re: Responses to City Comments
Proposed Project X Development
99 Bill Leathem Drive, 2 & 20 Leikin Drive & 11 Beckstead Road - Ottawa, Ontario

date: January 15, 2025

file: PG5876-MEMO.06

**Title: LIGHT WEIGHT FILL (LWF) PLAN**

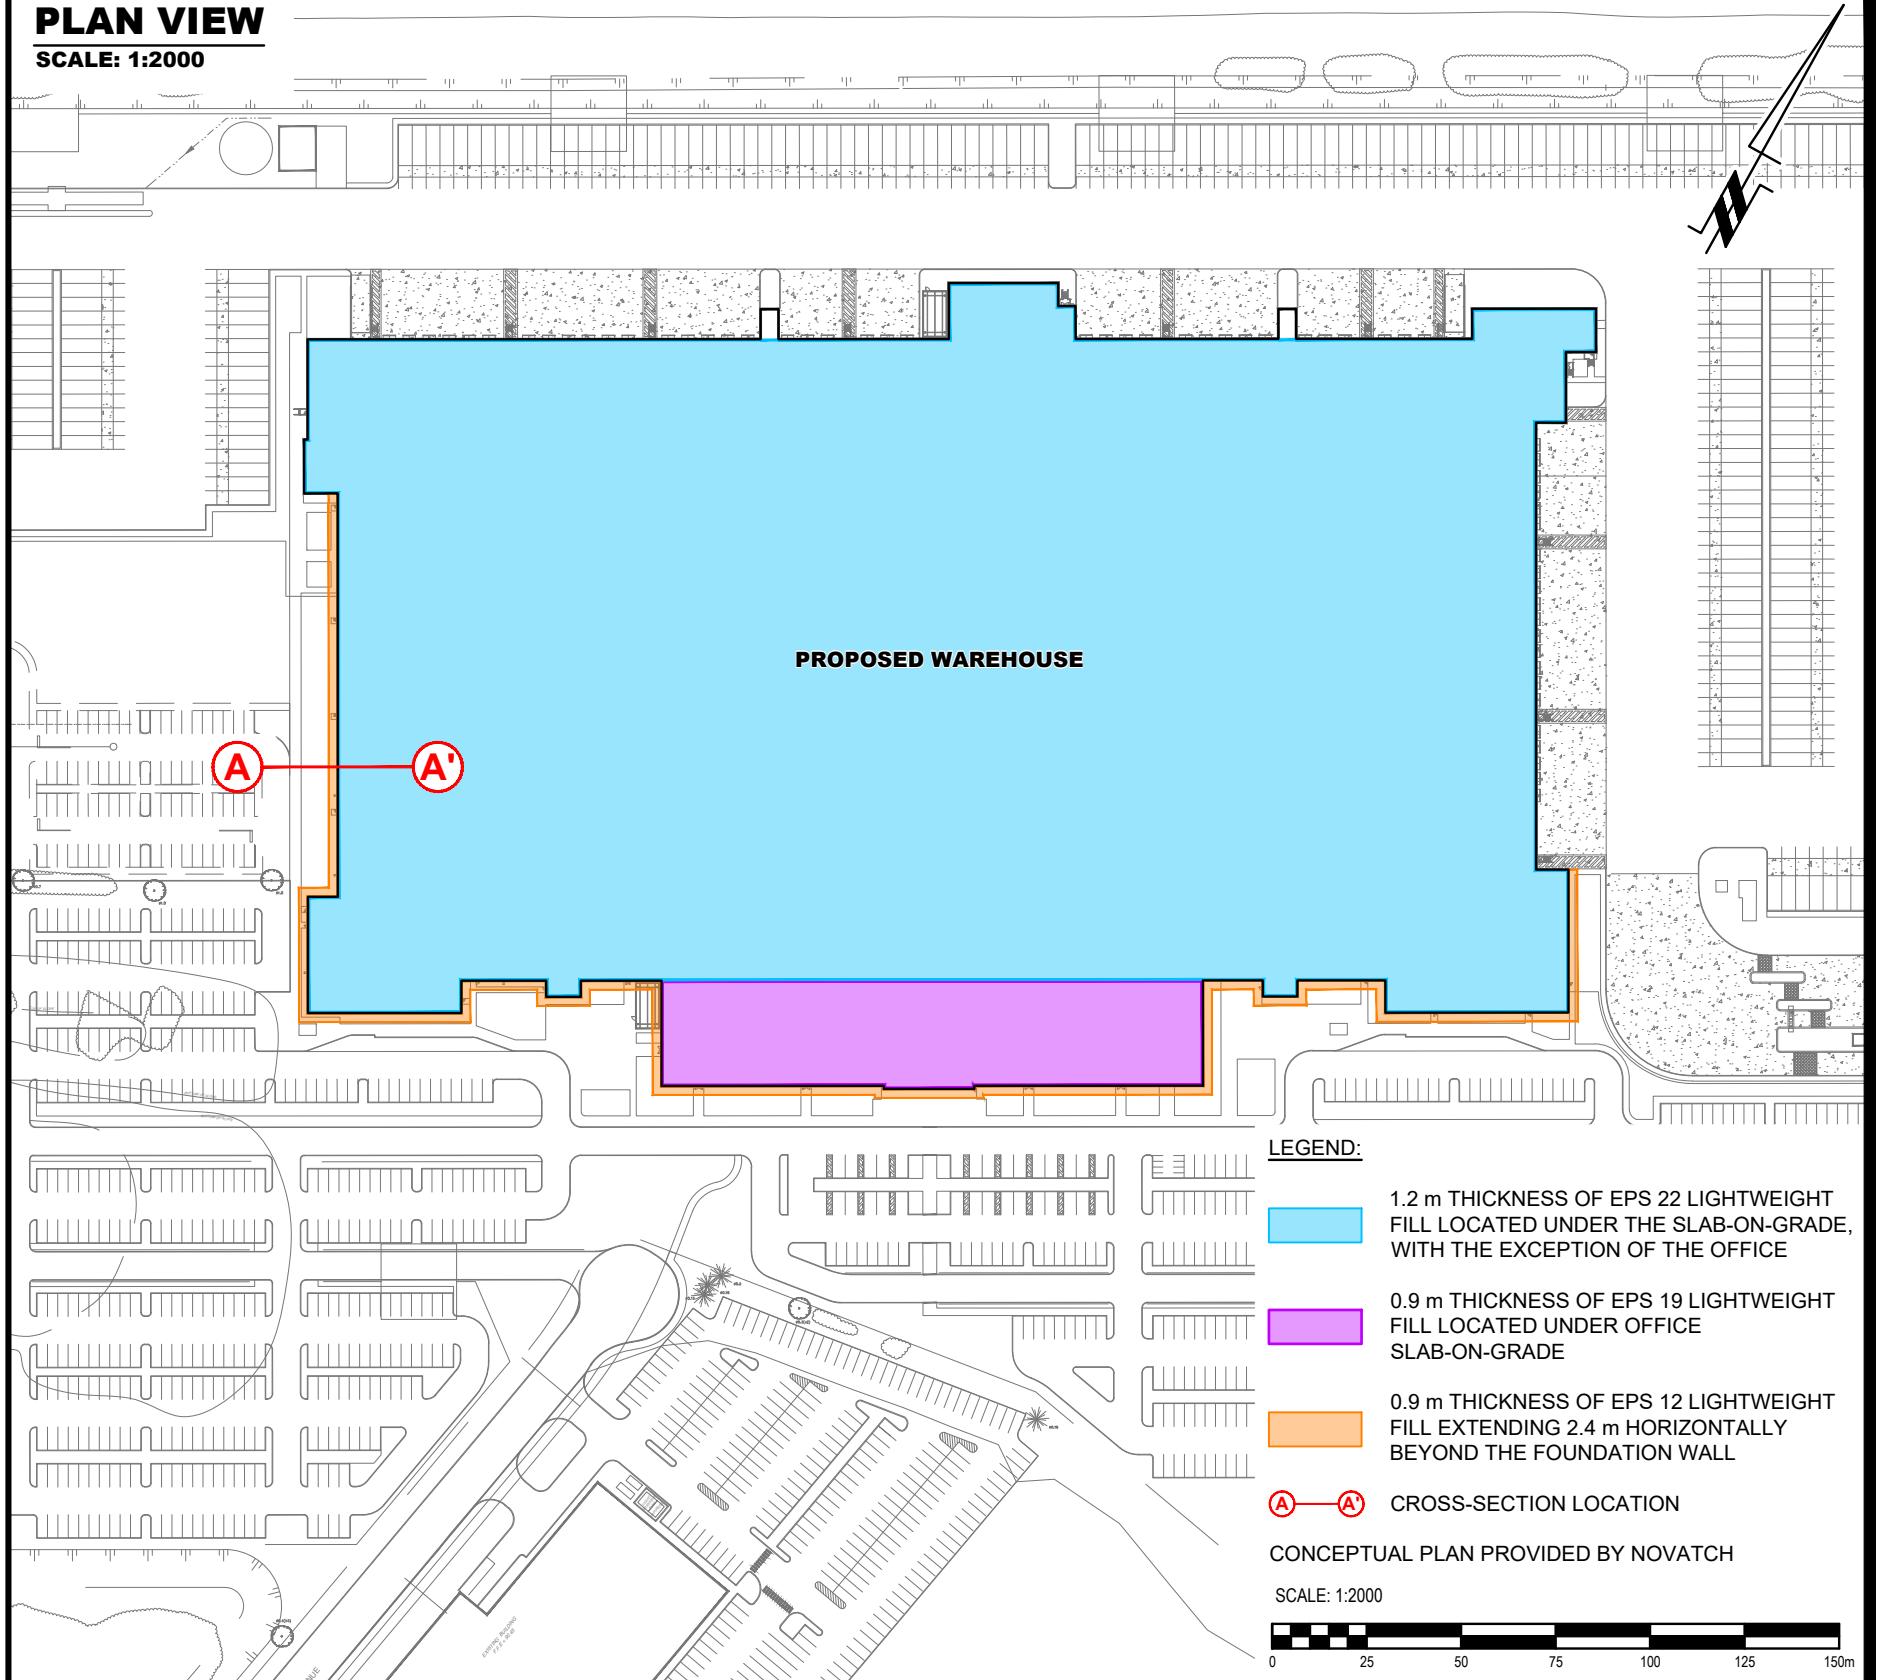
Comment B5: *Provide a separate memo providing a sign-off confirming that the grading plan and civil engineering design has respected the recommendations of the geotechnical report.*

Response: The Grading Plan Review is provided in the Paterson Group Memo PG5876-MEMO.07 dated January 15, 2025. In summary, lightweight fill is required under the proposed building's slab-on-grade. The lightweight fill details are provided on Drawing PG5876-G1, which is attached to the aforementioned memo and also included in Appendix 2 of the current Geotechnical Investigation Report, referenced above.
